From: Laura Gibbons <Laura.Gibbons@arun.gov.uk>
Sent: 15 February 2022 11:52
To: Planning.Responses <Planning.Responses@arun.gov.uk>
Cc: David Easton <David.Easton@arun.gov.uk>
Subject: RE: Planning Consultation on: BE/13/22/DOC

Engineers Comments Regarding Condition 10

Application No: BE/13/22/DOC

Description of Works: Approval of details reserved by condition imposed under BE/126/19/PL relating to condition 10-surface water drainage system.

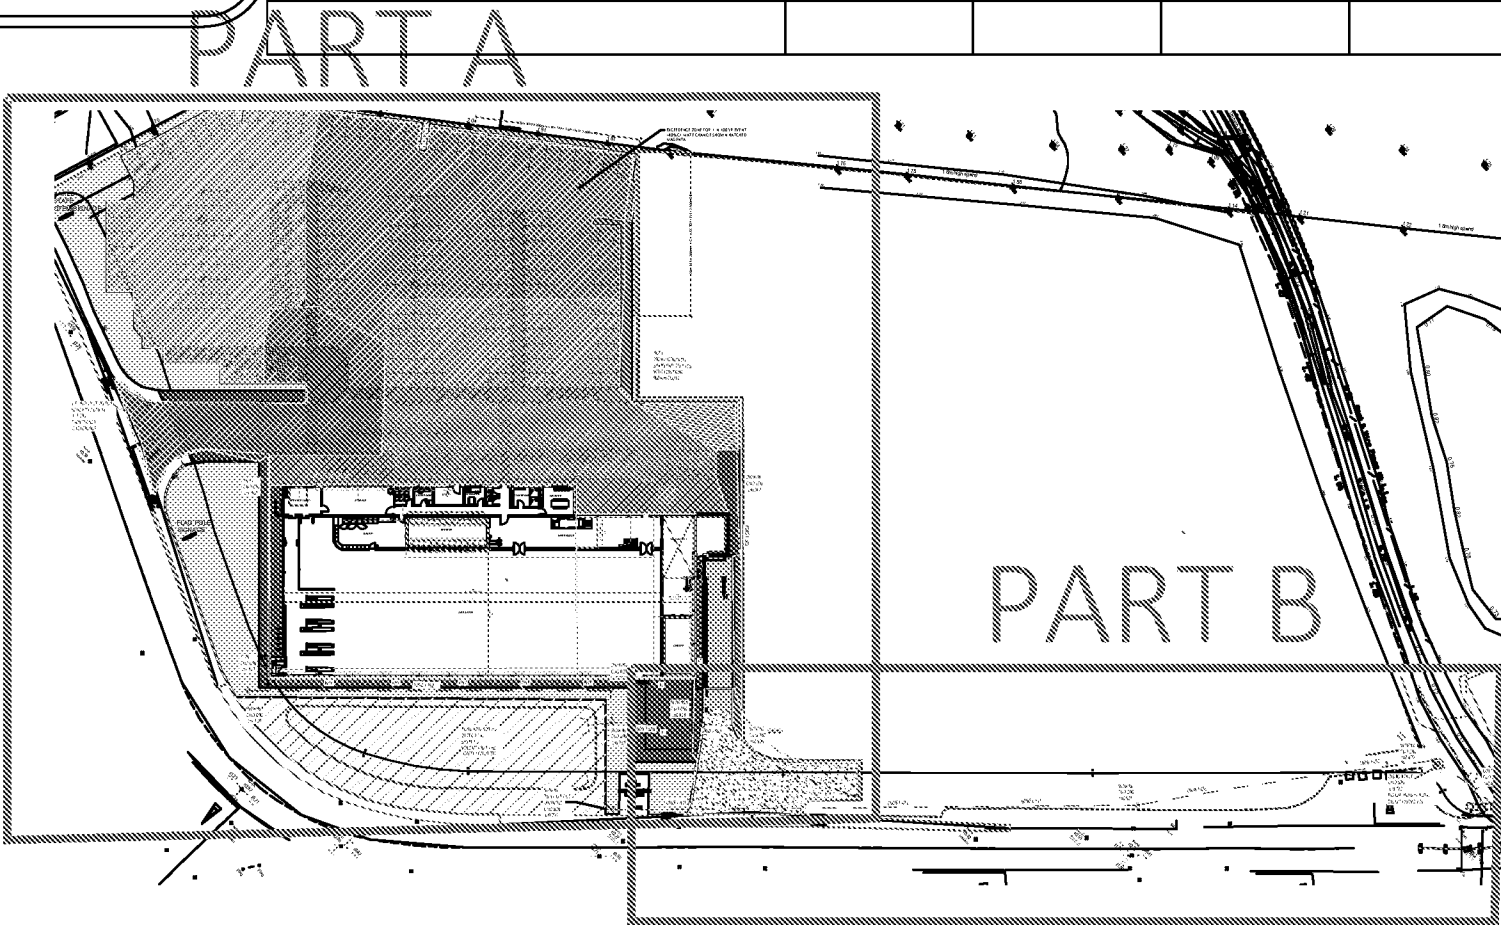
1. Car park levels have been constructed nearly 1m lower than the approved design. Modelled surface water flood depths are over 400mm. As per CIRIA C635 car park flooding should be kept to an absolute maximum of 200mm. Furthermore, ADEPT guidance is clear that flooding over 300mm is not suitable in vehicular areas. We therefore request that the applicant re-designs and eventually re-constructs some areas to ensure that flooding is reduced and kept to moderate depths only, i.e. less than kerb level.
2. Calculated impermeable area for the revised design appears to be substantially less than the approved design. Please detail catchment areas on plan, and explain where this reduction in impermeable area has been achieved.
3. There are several inconsistencies between calculations and layout including the outfall, hydrobrake and pond.

4. With the level of information provided it is difficult to verify the storage volume modelled at the delivery ramp, greater levels information is required.
5. The verification report does not meet the requirements of this condition. Please see our verification condition guidance note which details the information which is required to discharge this condition, this document can be found here: <https://www.arun.gov.uk/drainage-planning-consultations>,
